CITY OF ALBUQUERQUE

January 21, 2016

**RE: Holiday Inn Express – Copper Pointe
Conceptual Grading Plan
Engineer's Stamp Date 12-29-2015 (File: K21D009H3)**

GRADING CONSTRUCTION NOTES

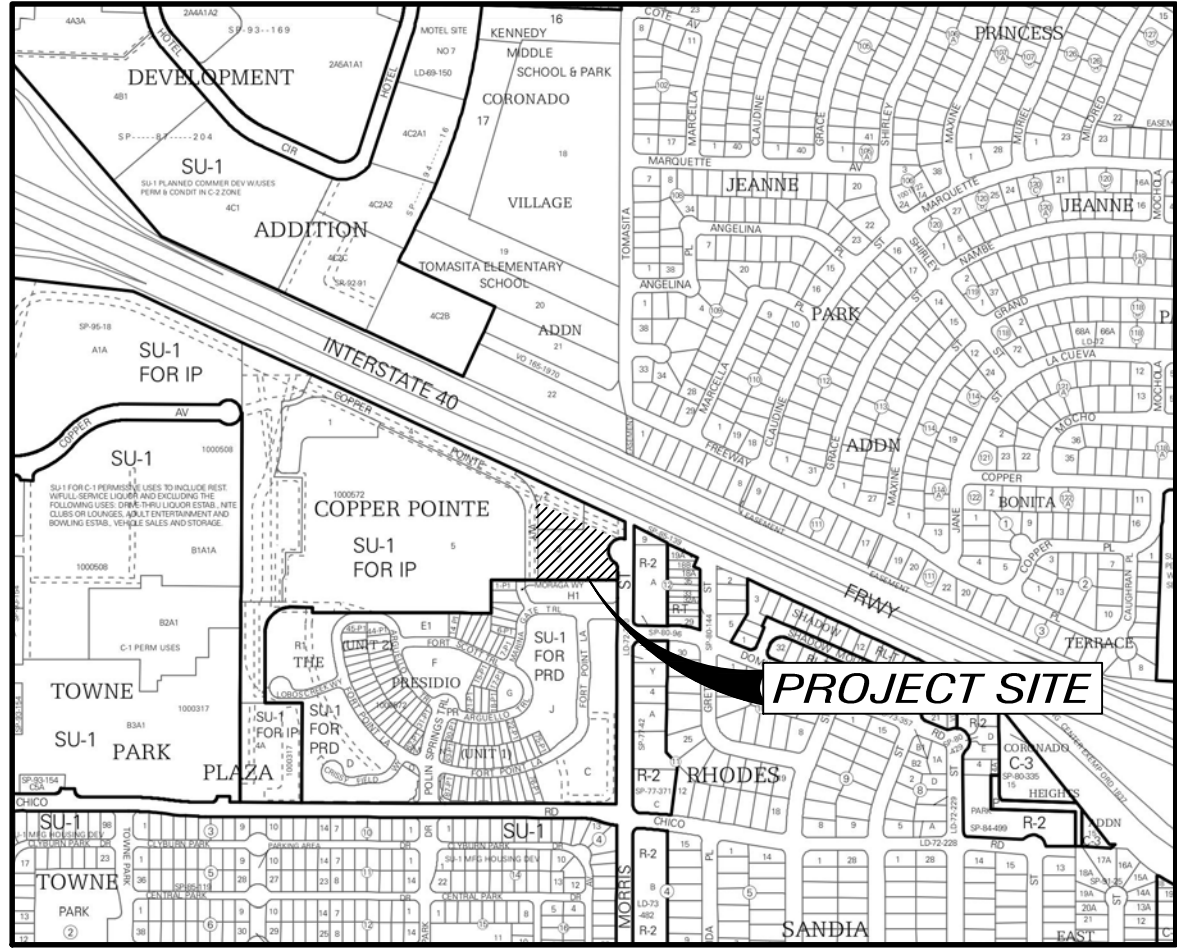
The drainage narrative states that the first flush will be stored in the perimeter landscaping areas. However, the access aisle appears to be conceptually shown with an inverted crown, and grades within the medians don't reflect a ponding area. Please note that we will expect the Final Grading and Drainage Plan to clearly show that the first flush pond is provided, *and* that Stormwater is directed to it.
